Drawing
Existing Elevations

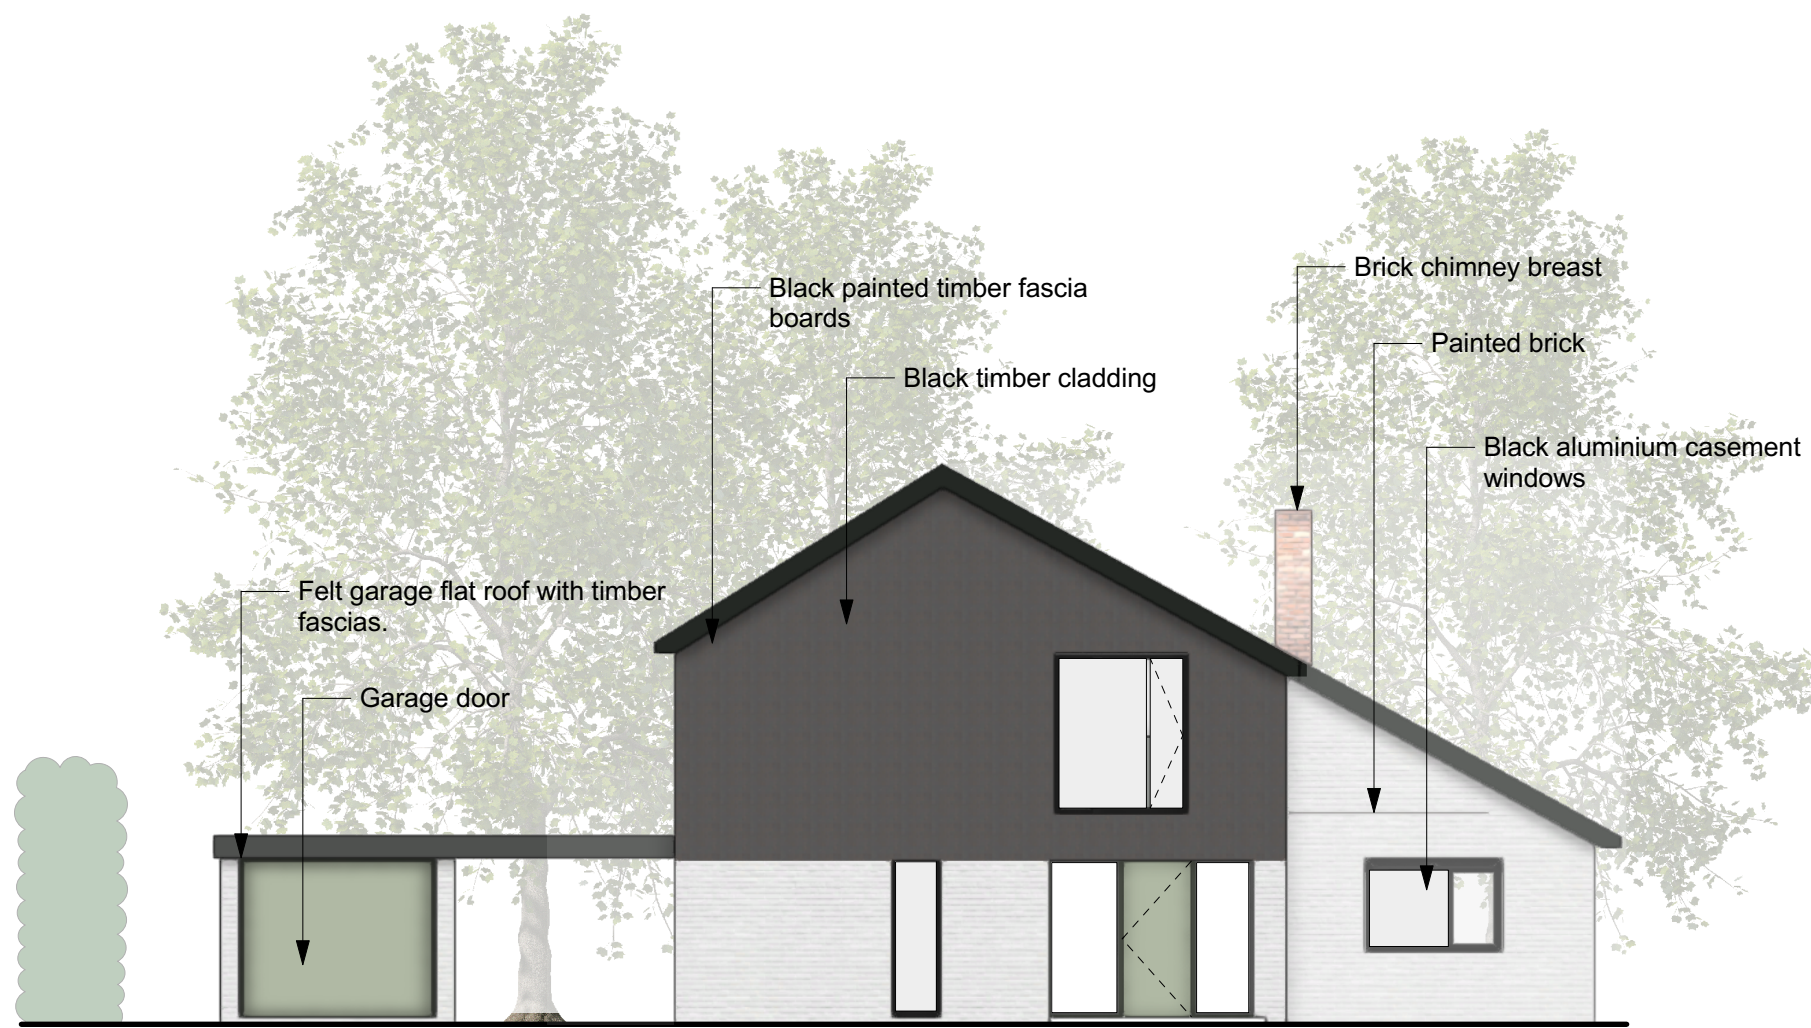
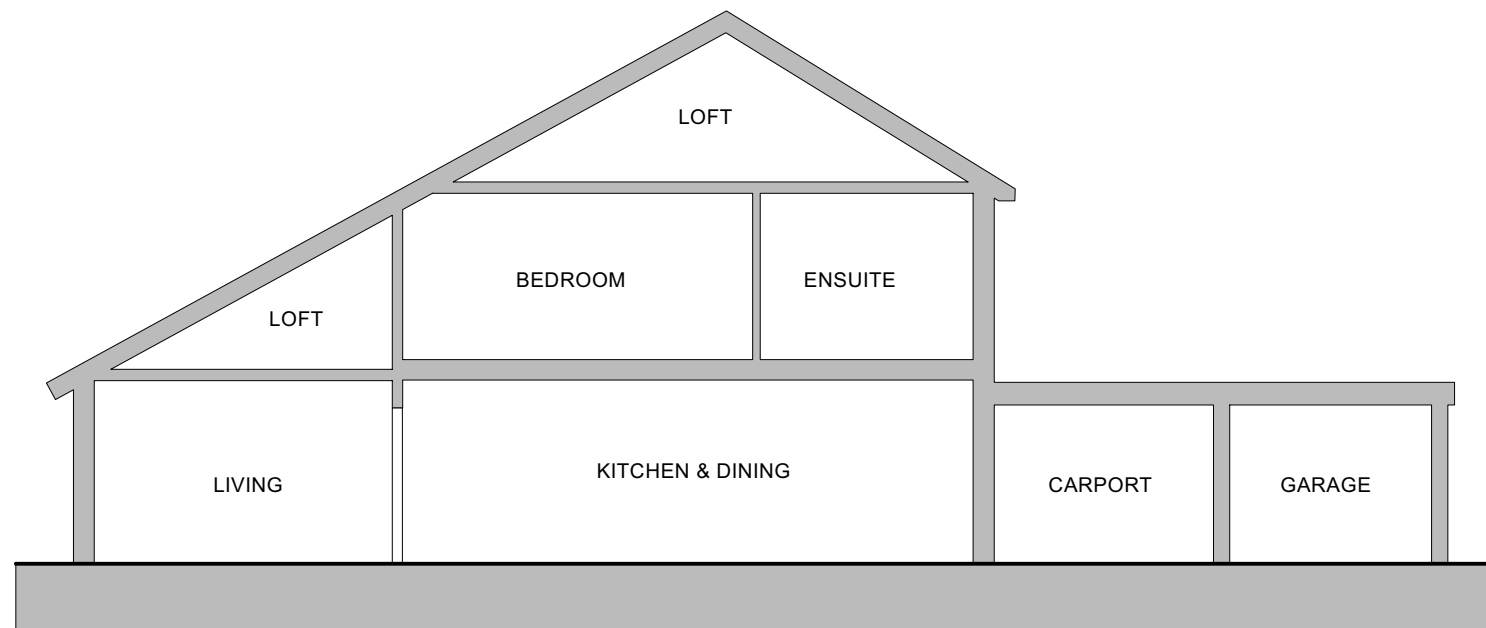
However, upon further inspection we have noticed the existing elevations are labelled as proposed. Please review and amend.

Apologies for this, please see attached the amended drawing.
